## MEMORANDUM

Date: Jun 19, 2015  
Project: 660 Forest Avenue, Portland, ME  
From: David Tetreault  
Subject: Structural Review of Proposed Renovations

① SECTION @ HOOD
1/2" = 1'-0"

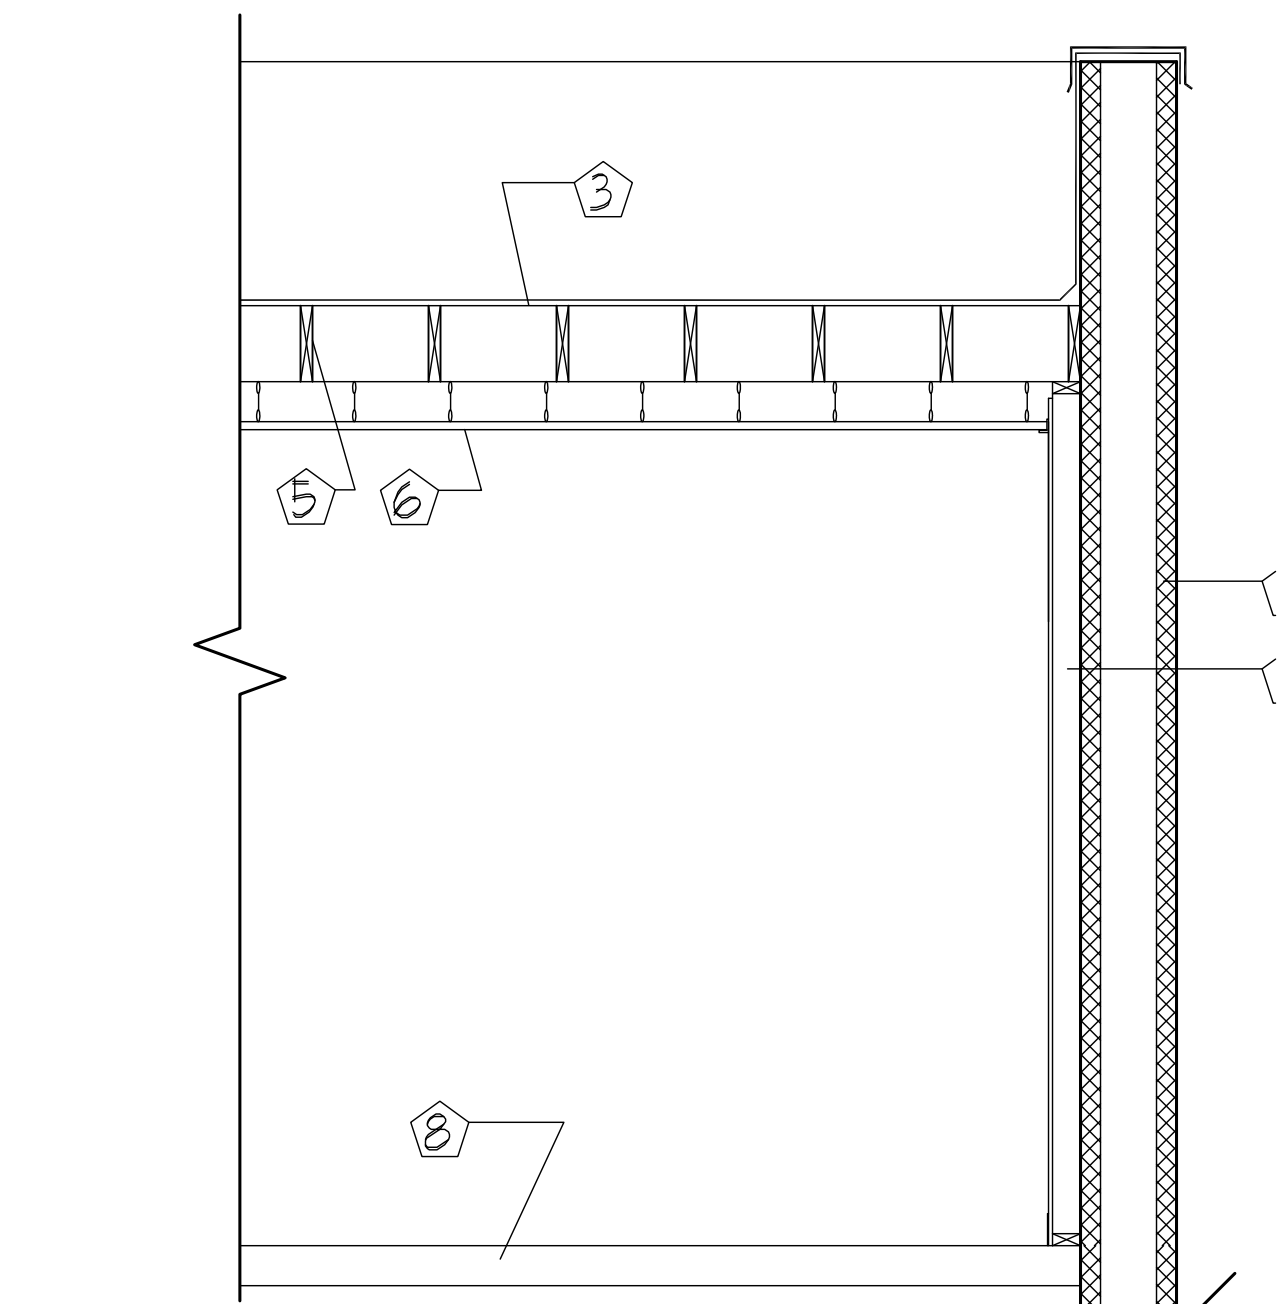
**Support of a new kitchen hood and roof top fan**

It is structurally acceptable to install a new kitchen hood weighing 715 pounds and a roof top mounted fan weighing 225 pounds supported by the existing 2x10 roof joists.

④ DEMOLITION PLAN
1/8" = 1'-0"

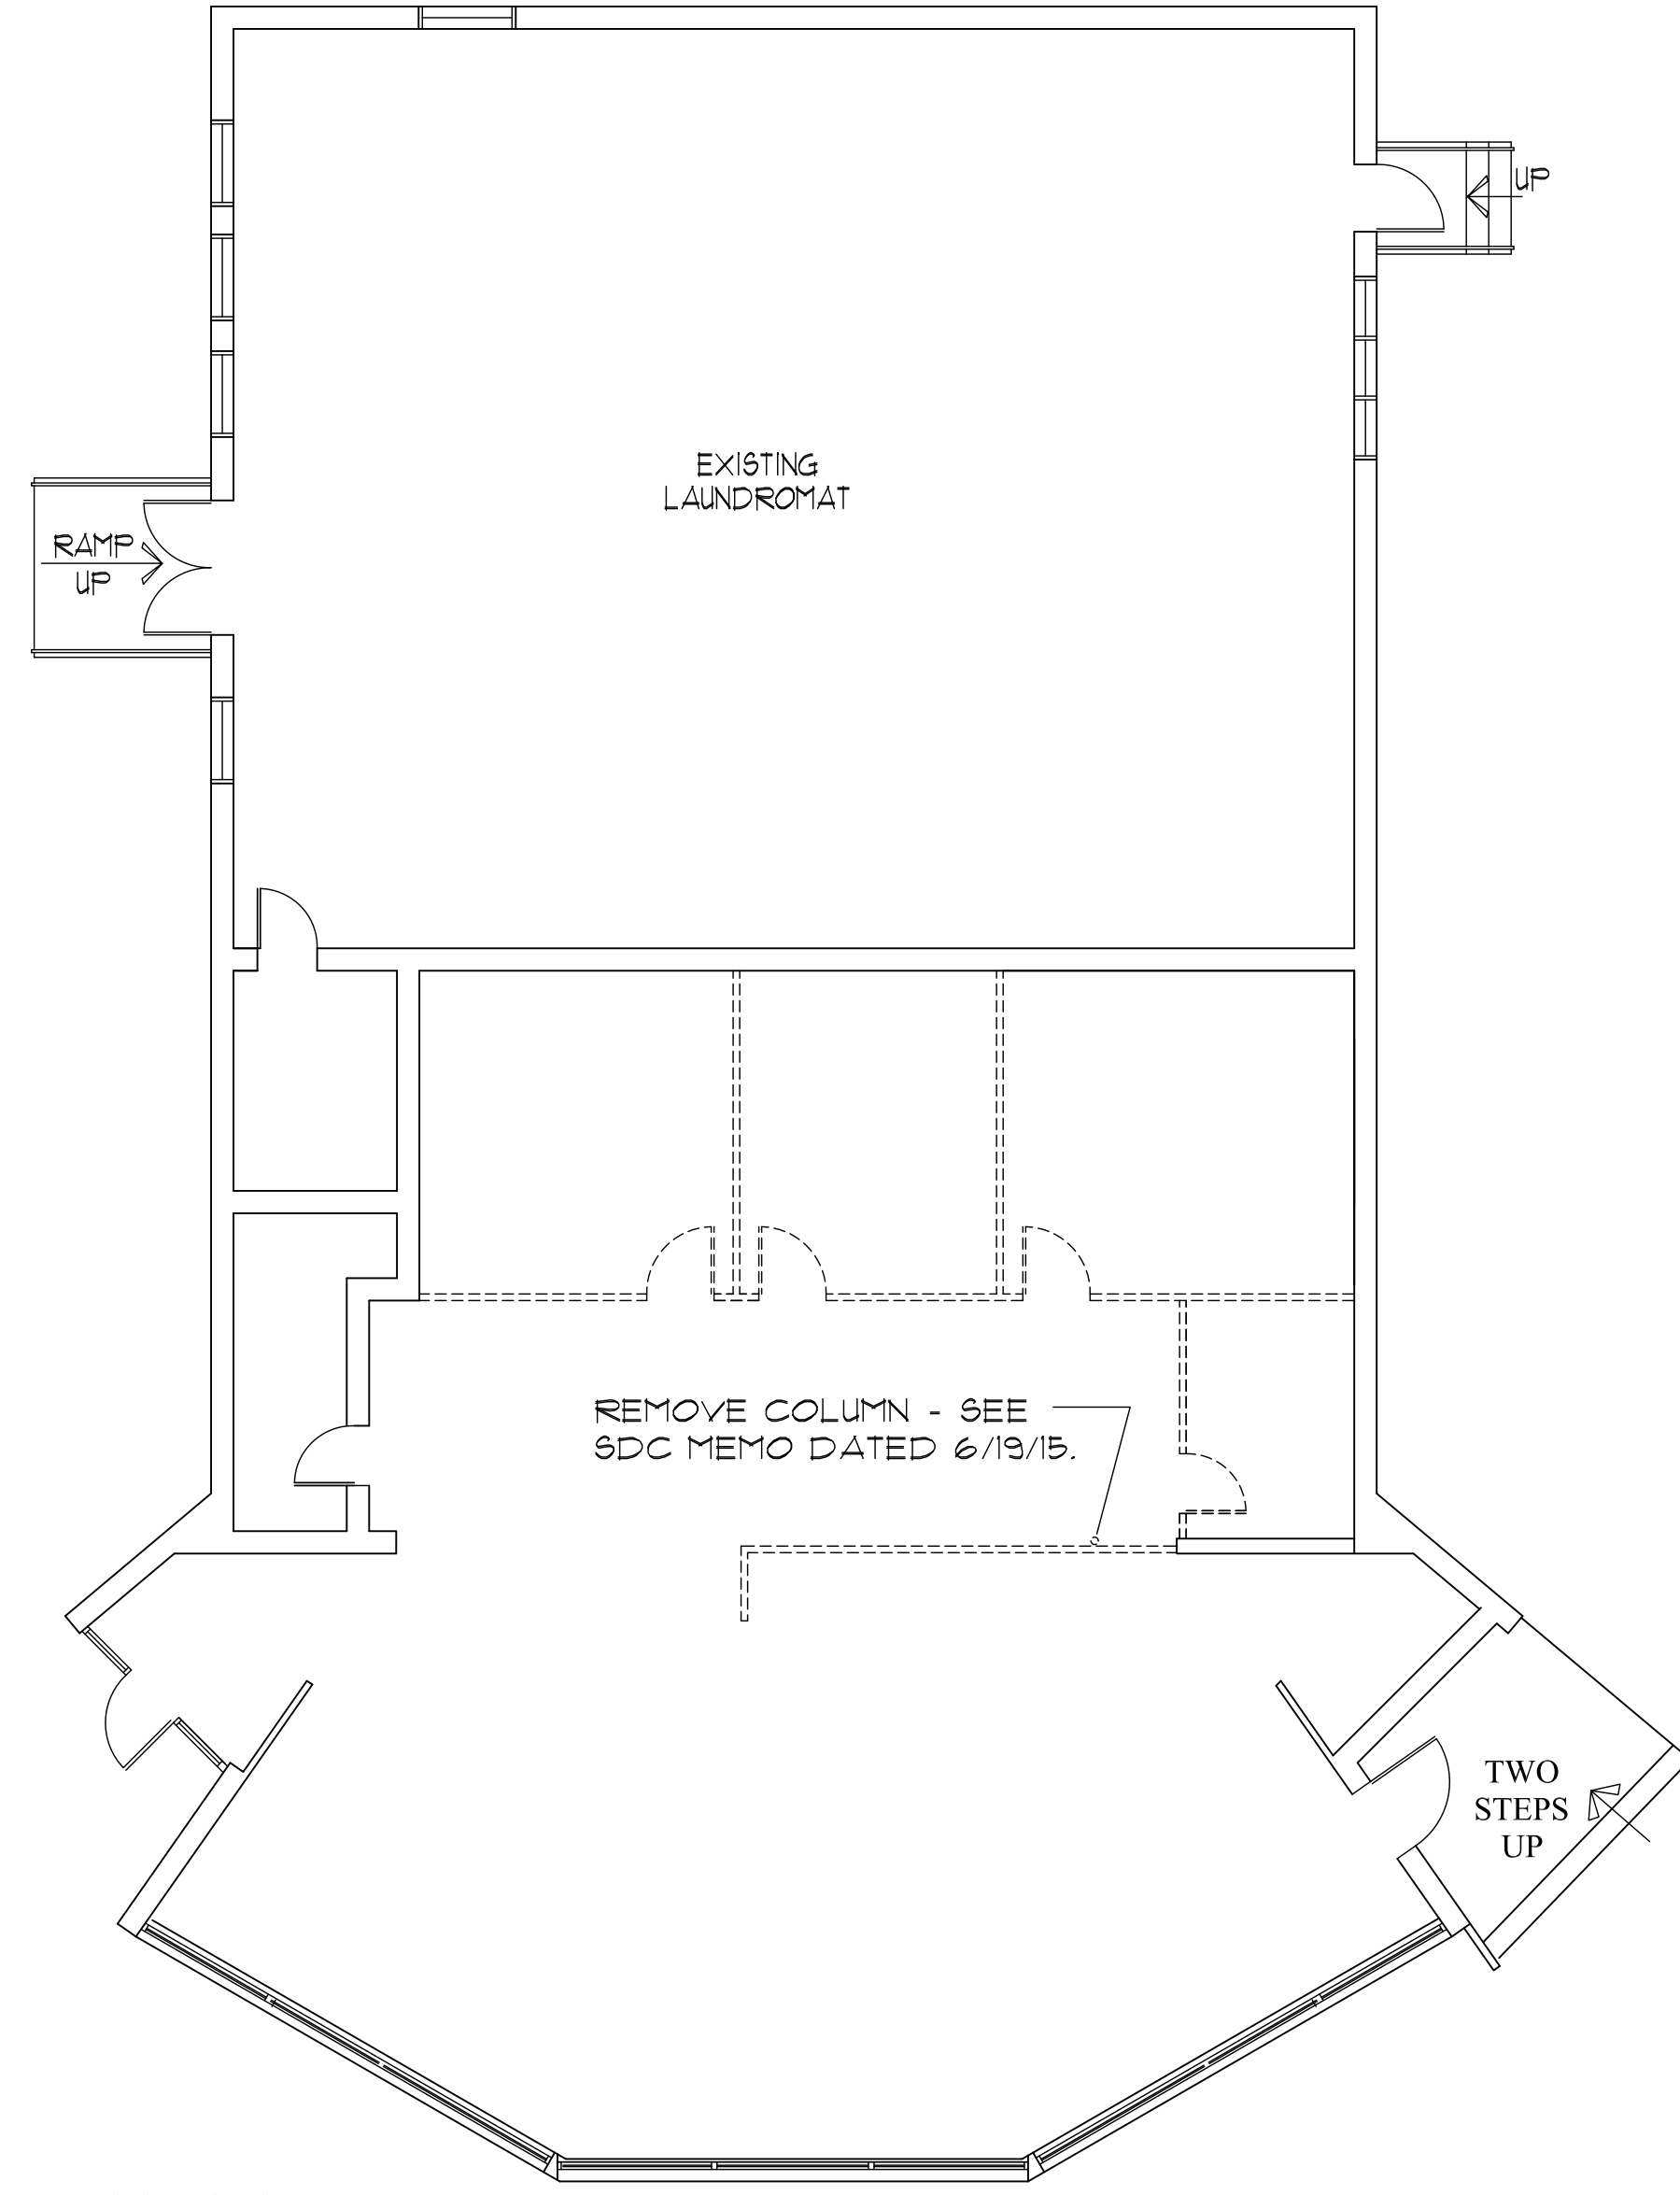
**Relocation of a steel column supporting a steel beam at the rear of Bar 106**

It is proposed to relocate the existing steel column 3'-11" towards the interior of the building so that it is at the center of Bar 106. This relocation is structurally acceptable. A new footing matching the existing footing must be placed at the new column location.

**Removal of wall beneath a steel beam located within Kitchen 100**

The existing wall is a non-bearing wall and can be removed. However, it is likely that steel column(s) are present in the wall. The steel columns must not be removed or relocated without further inspection and structural analysis.
